**CITY OF ALBUQUERQUE
PLANNING DEPARTMENT
Development Review Board
4/2/03 Comments**

Project # 1002559

Application # 03DRB-00476

Subject: Desert Highlands @ La Cueva Subdivision

SKETCH PLAT
TRACTS N-2B-1A AND N-2B-1B
SEVEN-BAR RANCH
(BEING A REPLAT OF TRACT N-2B-1, SEVEN-BAR RANCH)
WITHIN PROJECTED SECTIONS 6 & 7, T.11N., R3E., N.M.P.M.
THE TOWN OF ALAMEDA GRANT
CITY OF ALBUQUERQUE
BERNALILLO COUNTY, NEW MEXICO
MARCH 2003

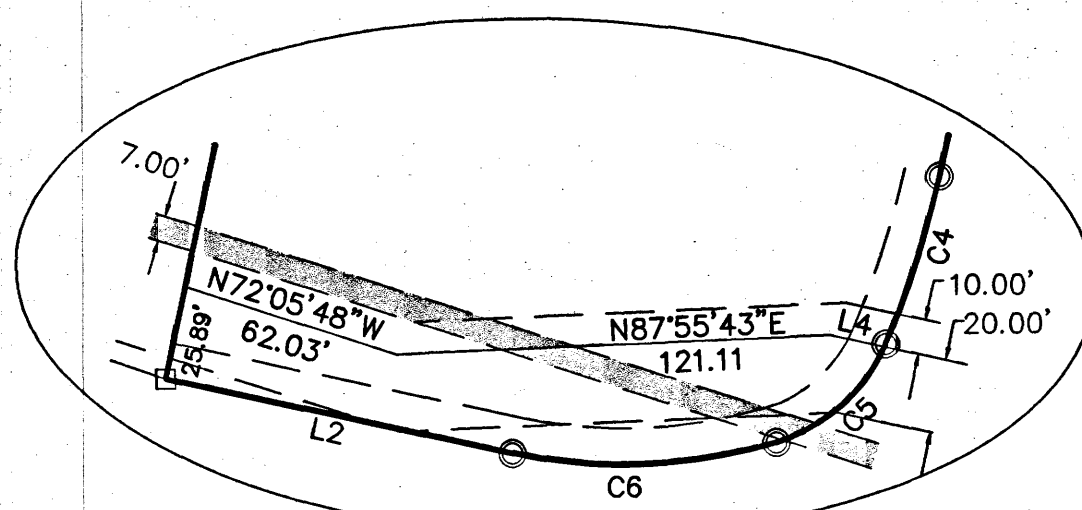
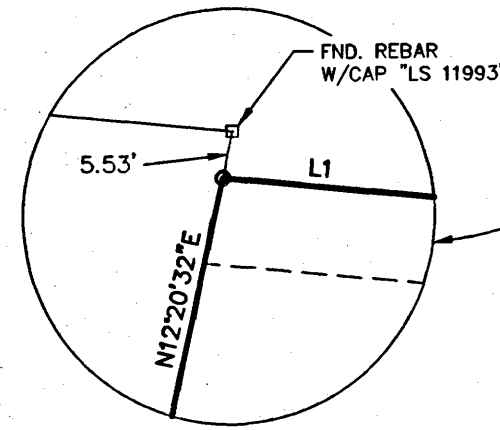
Written proof of re-zoning required at preliminary plat approval.

Point of information, the Seven Bar Sector Plan has SU-1 attached to commercial uses.

Sector Plan designates the area as open space.

No.	Comment
<input type="checkbox"/>	What is proposed?
<input type="checkbox"/>	The Coors Corridor plan needs to be adhered to.
